DATE: 23 May 2013
TO/COMPANY: Christopher Grimaldi – Consigli Construction
PROJECT: UNUM HOI Basement and Dock Renovations
FROM: Chad Reed
PAGES: Large format drawings + thumb drive
RE: Portland Fire Dept. Follow up

Attached find (1) thumb drives containing .pdfs of drawings plus 30x42 sheets for distribution to LT. Wallace regarding follow up questions.

REGISTERED ARCHITECT
BRIAN
12-124
PDT JOB NO.
DRAWN
JKP
SCALE
1/16" = 1'-0"
ISSUE: 29 APRIL 2013
IFC SET
TITLE
HOI-BASEMENT FLR.
PHASING & CODE
DIAGRAMS, CODE
SUMMARY & LEGEND
SHEET
A-001

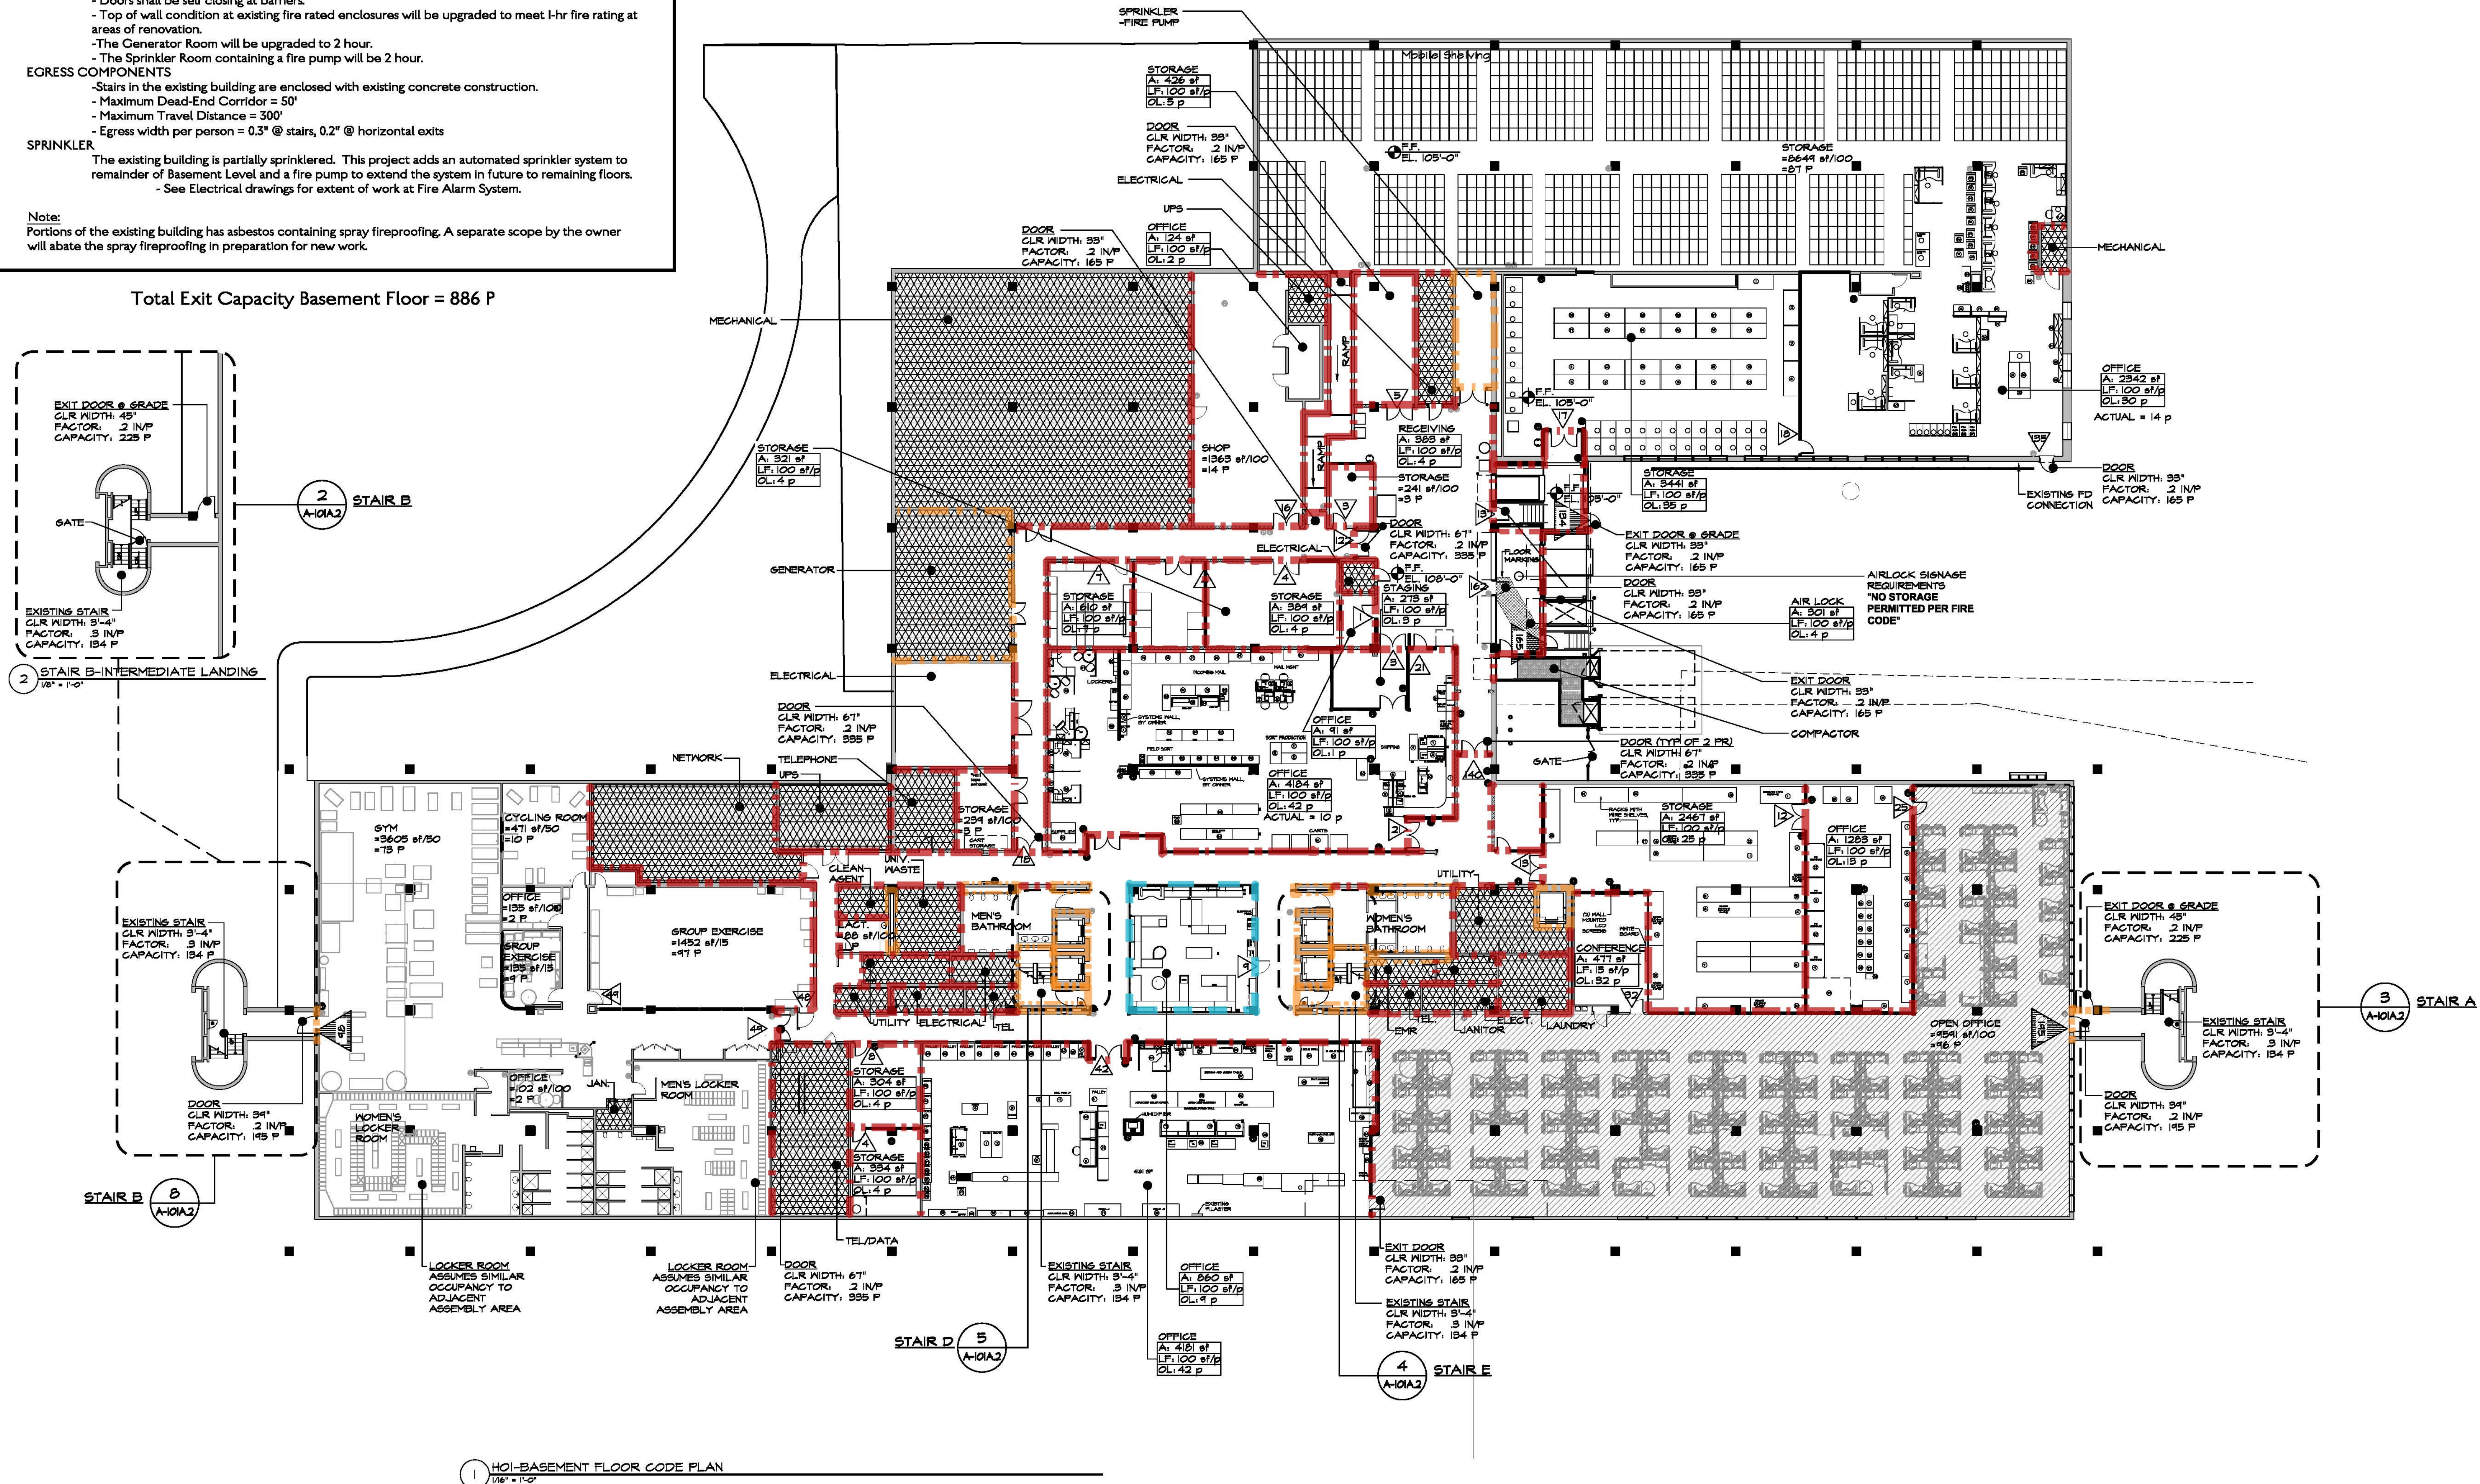
A-001	HOI-Basement Flr. Phasing & Code Diagrams, Code Summary & Legend	Addresses rating change, signage posting and floor markings. (Items 3,6)
A-101A.2	HOI-Enlarged Partl. Plans –Stairs	Clarify door replacement at D&E Stairs 2&3 rd floor (Item 4)
A-III A	HOI-Basement Flr. Ref. Ceiling Plan Area A	Removes conflicting exit sign information, see EL drawings update (Item 5)
A-IIIB	HOI-Basement Flr. Ref. Ceiling Plan Area B	Removes conflicting exit sign information, see EL drawings update (Item 5)
A-IIIC	HOI-Basement Flr. Ref. Ceiling Plan Area C	Removes conflicting exit sign information, see EL drawings update (Item 5)
A-IIID	HOI-Basement Flr. Ref. Ceiling Plan Area D	Removes conflicting exit sign information, see EL drawings update (Item 5)
A-504	General details	Detail updated regarding Handrail extension (Item 1)
A-601	HOI Door Schedule, Types, Frames	Updates Rated OVHD Doors (Item 2)
EL-101A	Electrical Lighting Ground Floor Part Plan Area A	Revised Exit sign locations (Item 5)

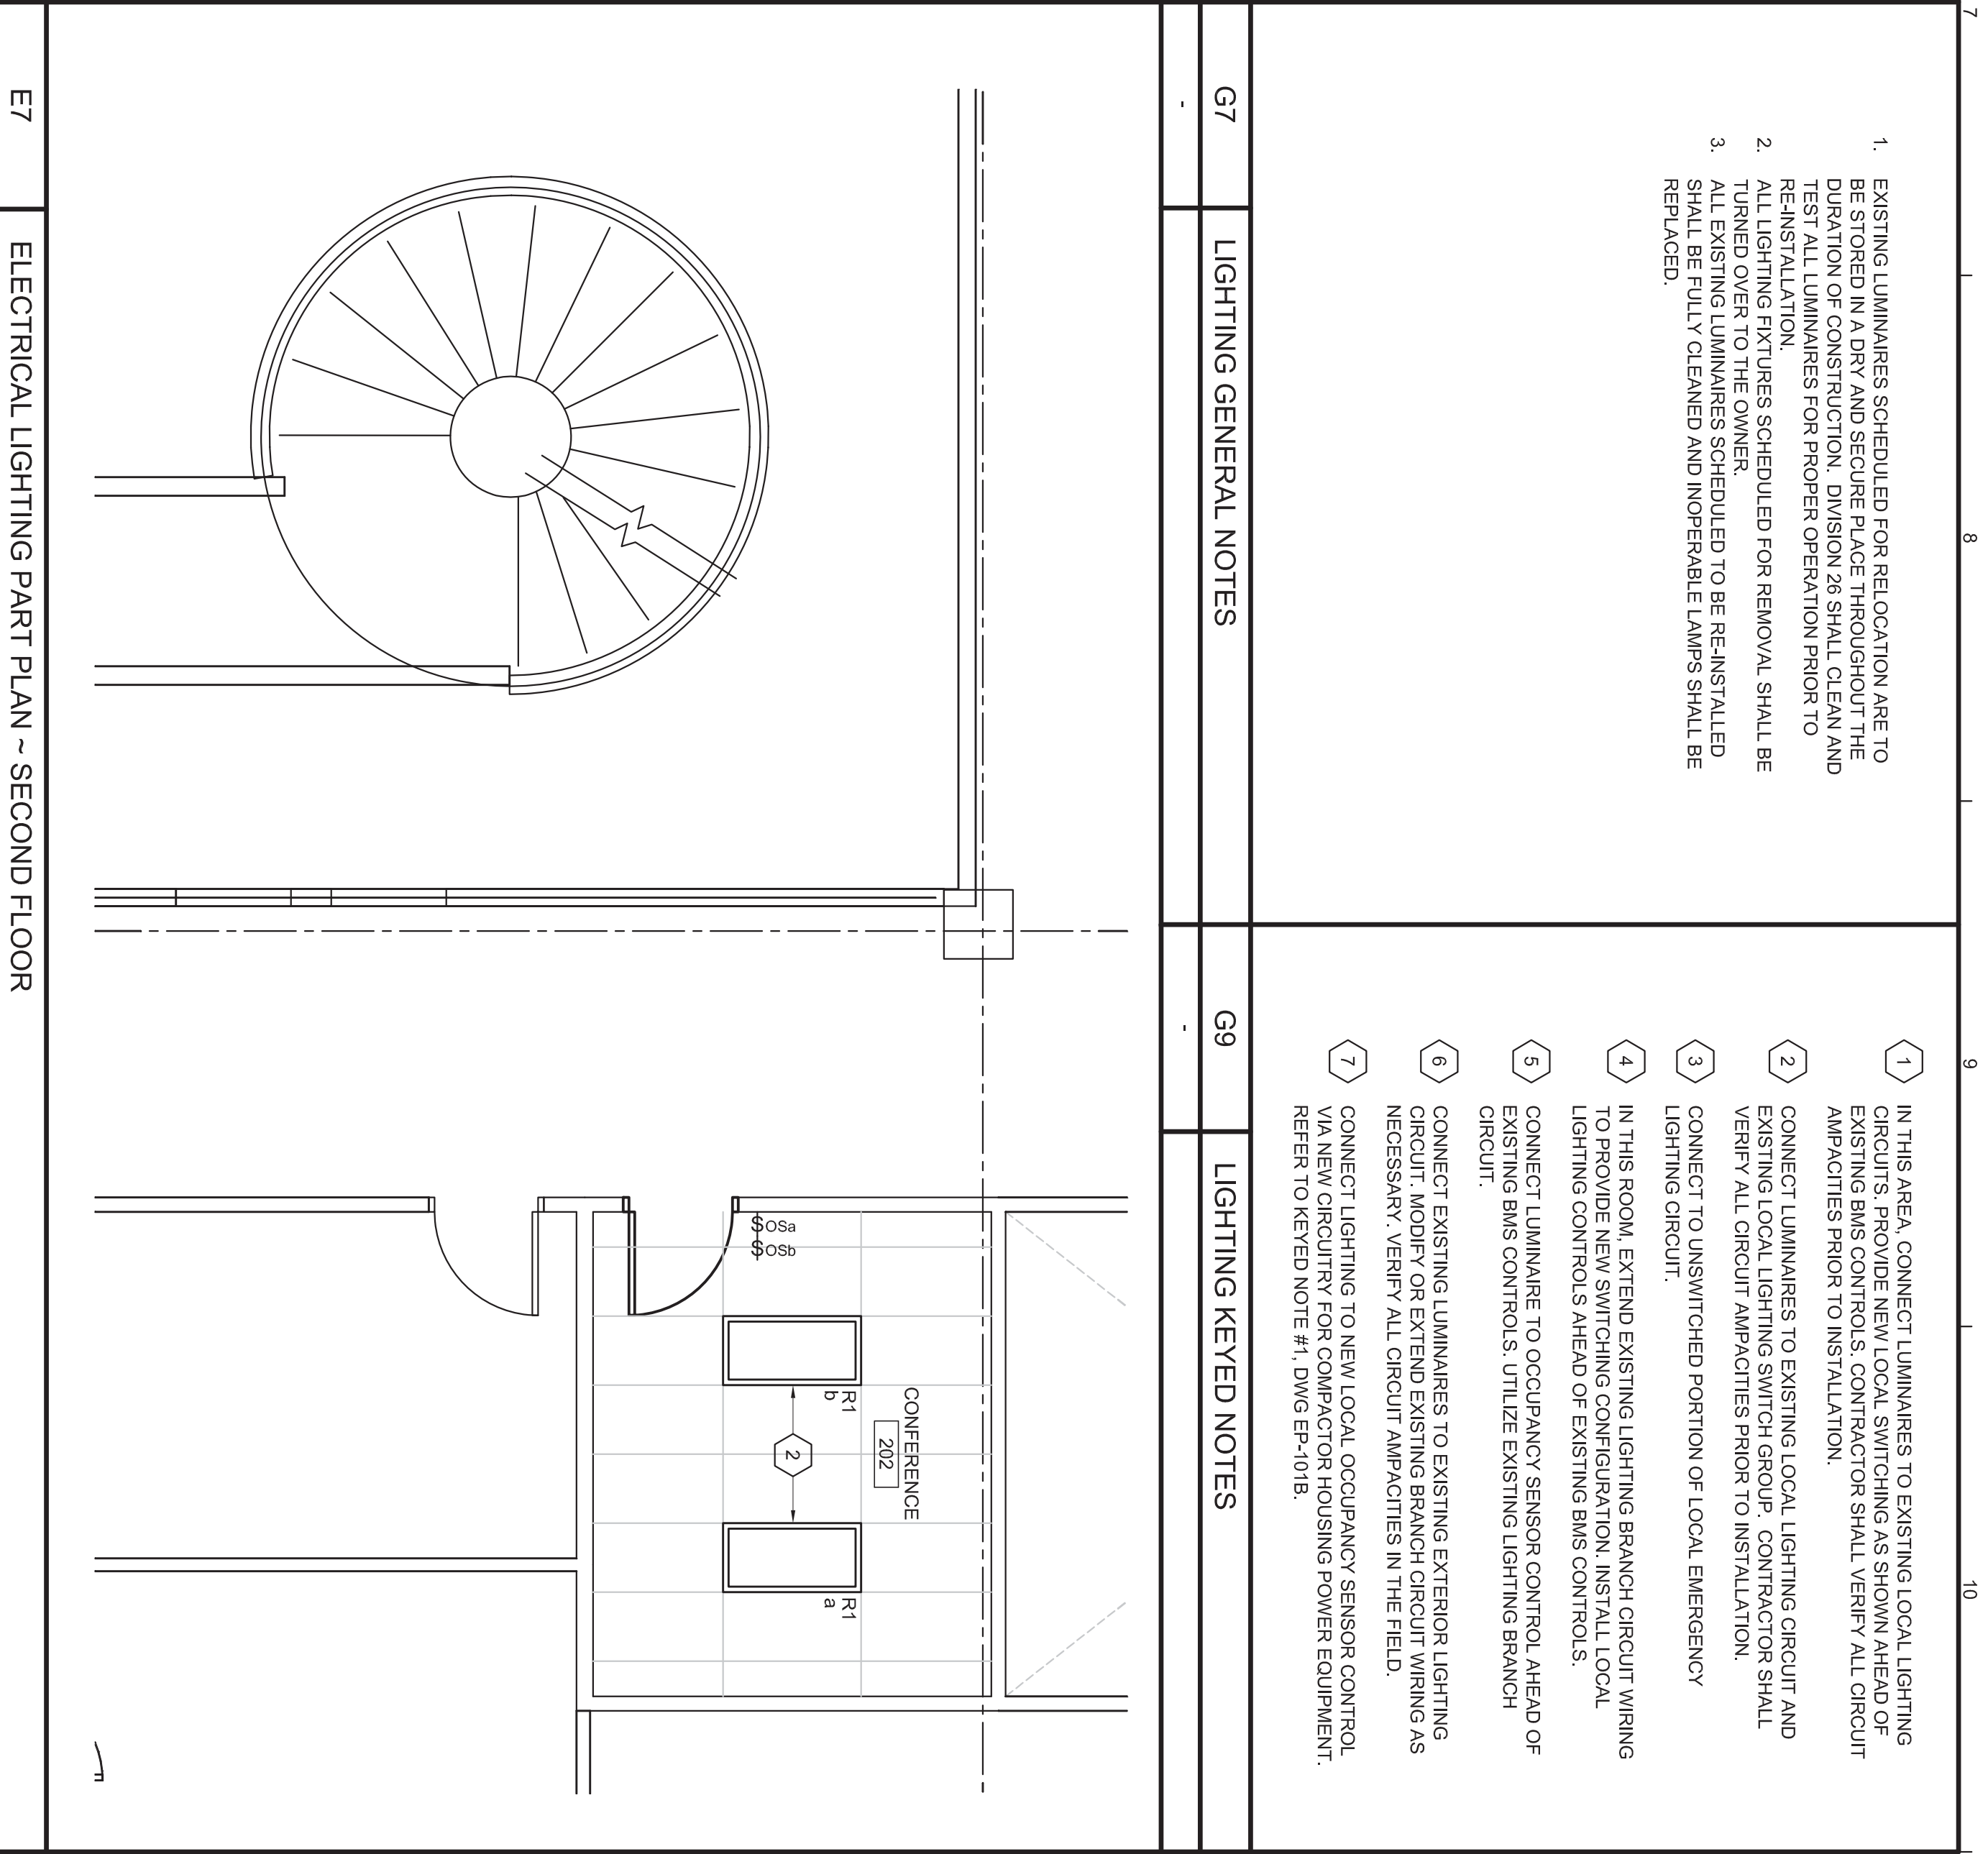
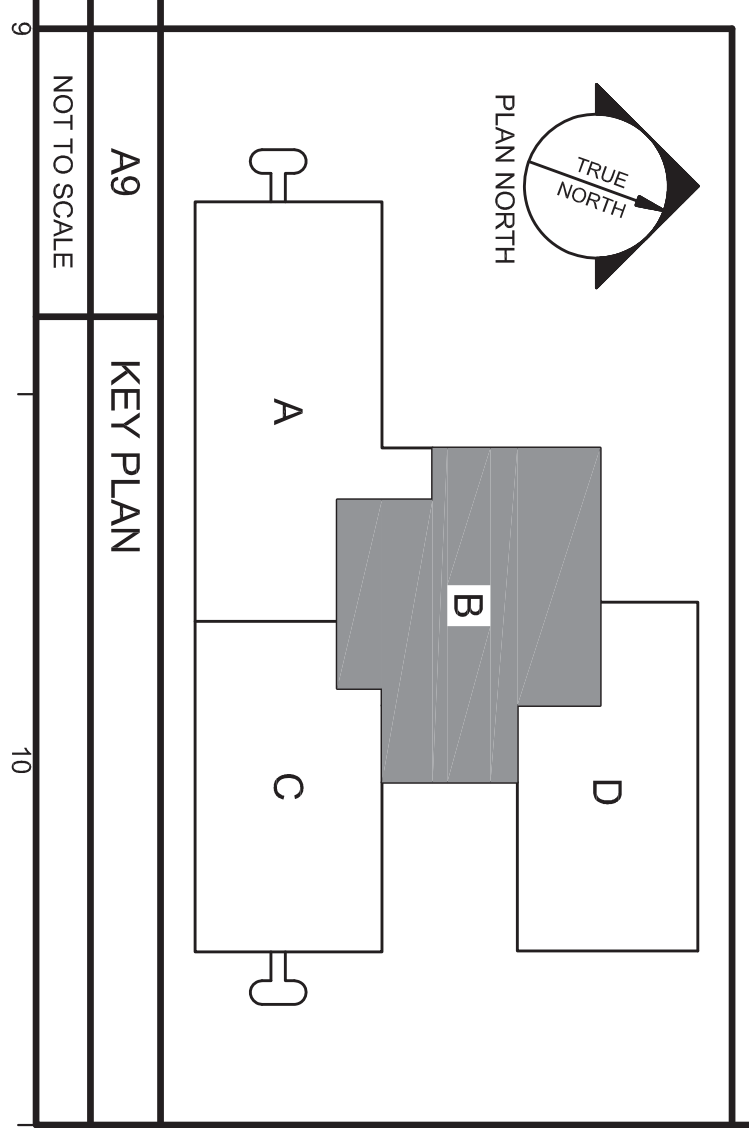
EL-101B	Electrical Lighting Ground Floor Part Plan Area B	Revised Exit sign locations (Item 5)
EL-101C	Electrical Lighting Ground Floor Part Plan Area C	Revised Exit sign locations (Item 5)
EL-101D	Electrical Lighting Ground Floor Part Plan Area D	Revised Exit sign locations (Item 5)
